OBJECTION

Application Reference 6/2021/2752/VAR
Variation of Condition 18 (revised layout) on planning permission 6/2019/2752/VAR

Drawing Title  
Proposed Elevations 2 of 2

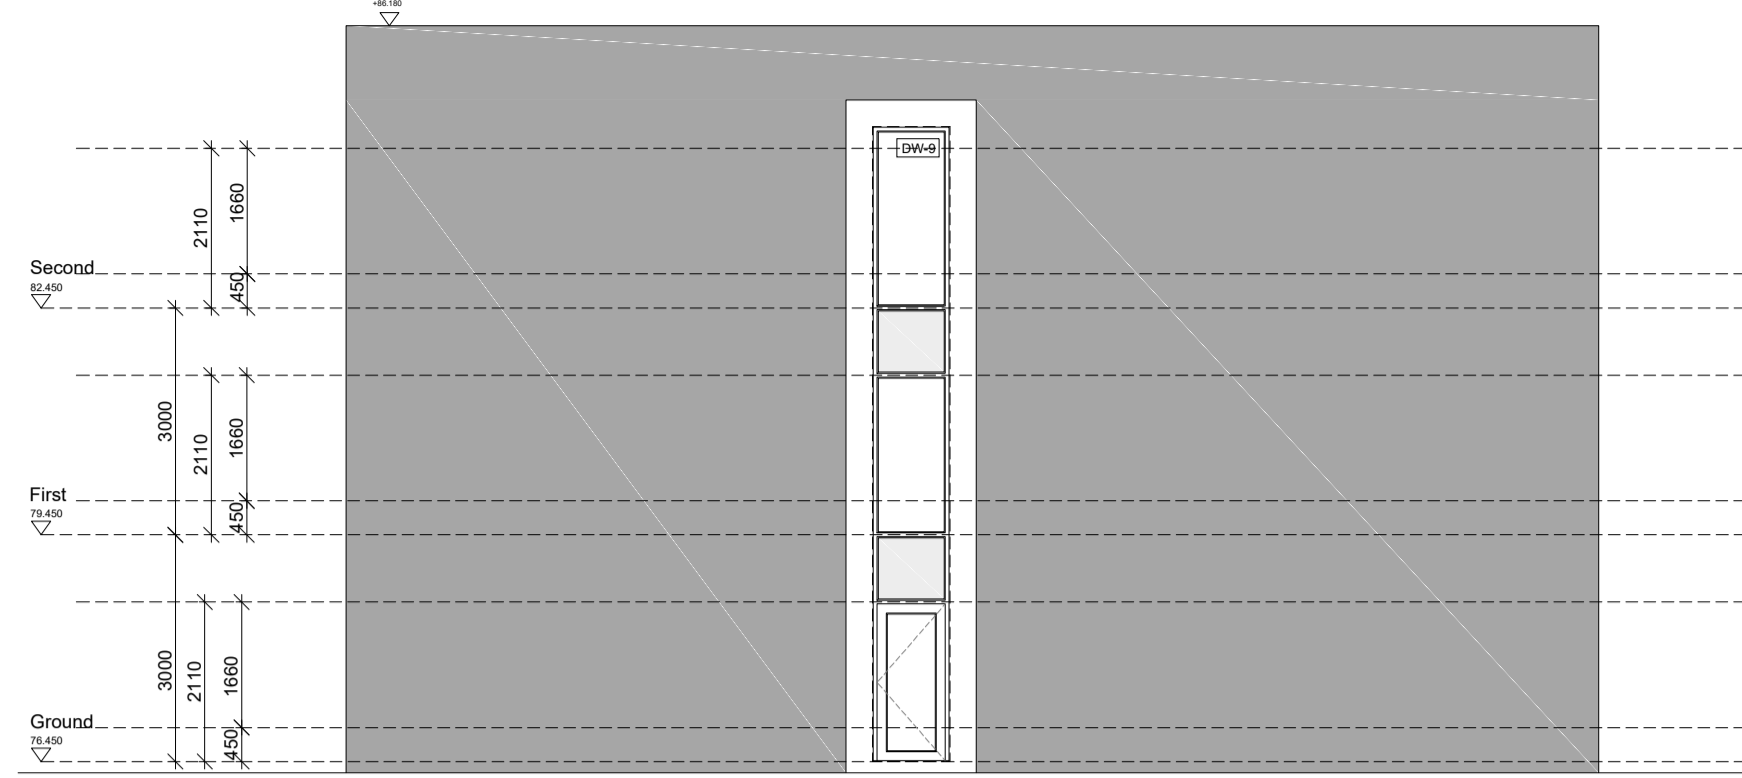
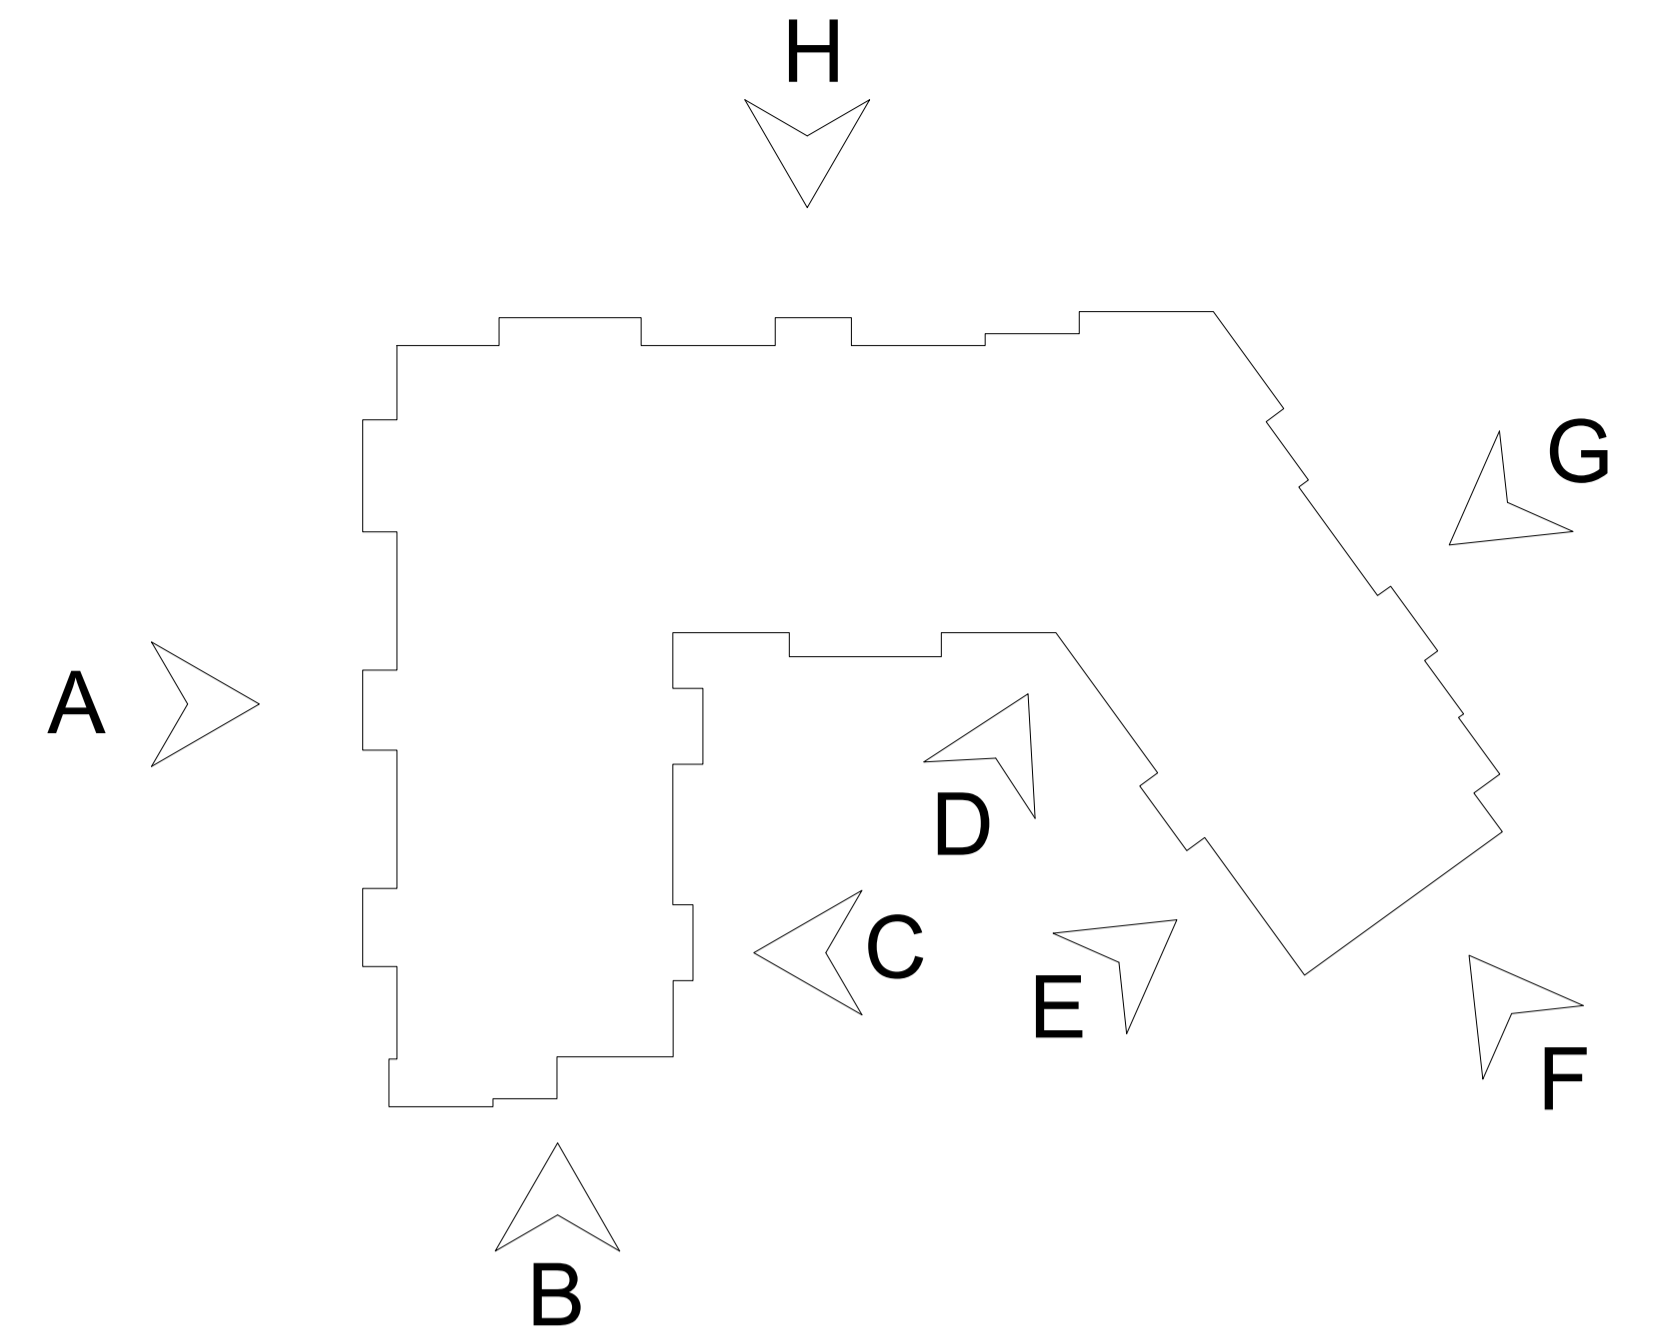
- **Plant Room on North Elevation facing Manor Road**
- **Main Kitchen on first floor North Elevation facing Manor Road**
- **Laundry Room on Ground Floor North Elevation facing Manor Road**
- **Removal of balconies from North Elevation**
